Application number: 2023/91280	
What is the application for?:	Quarrying operations for the extraction of clay, shale and incidental coal and s
Address of the site or building:	Bromley Farm Quarry, Barnsley Road, Upper Cumberworth, Huddersfield, HD8 8PD
Postcode:	S36 4HG

Type of comment: An objection	
Do you wish your comments to be published on the website anonymously?	No

ACCESS TRACKING

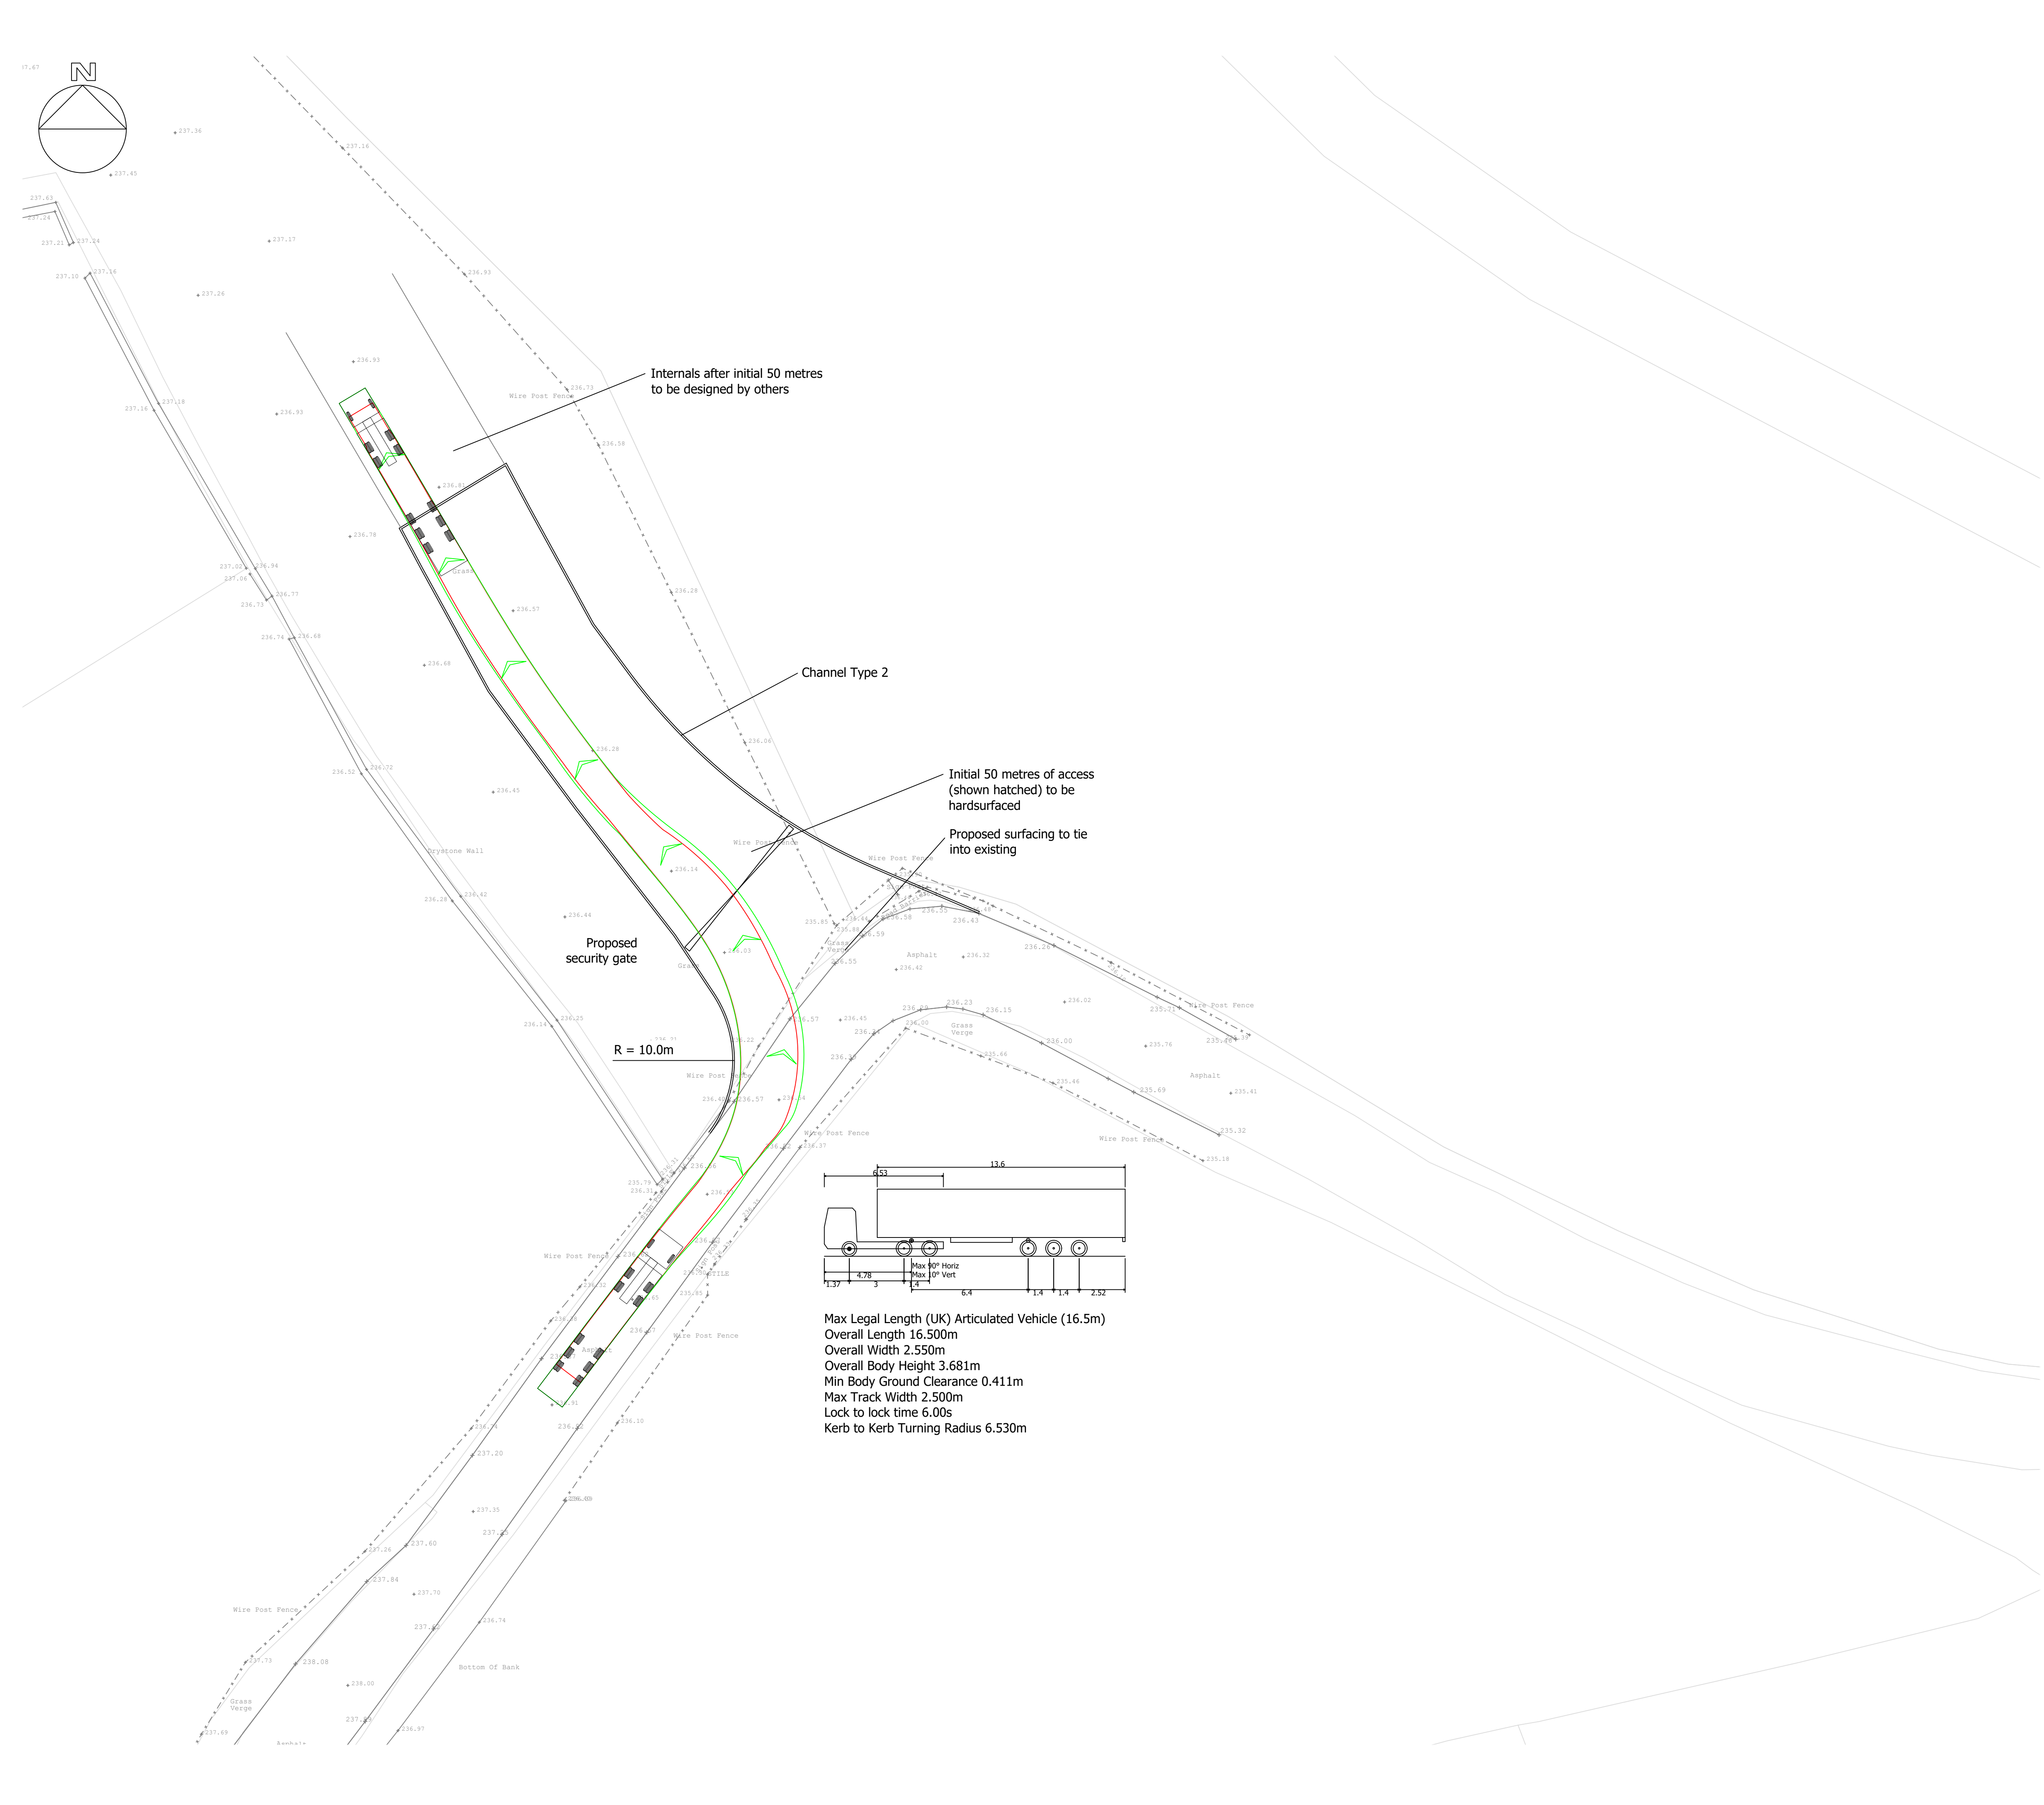
7 The access road into the quarry should be at least 8.92 meters wide NOT 6 METERS as suggested by Kirklees. No consideration has been given to pedestrians crossing the road on the public footpath that crosses the access road. Where is the risk appraisal?
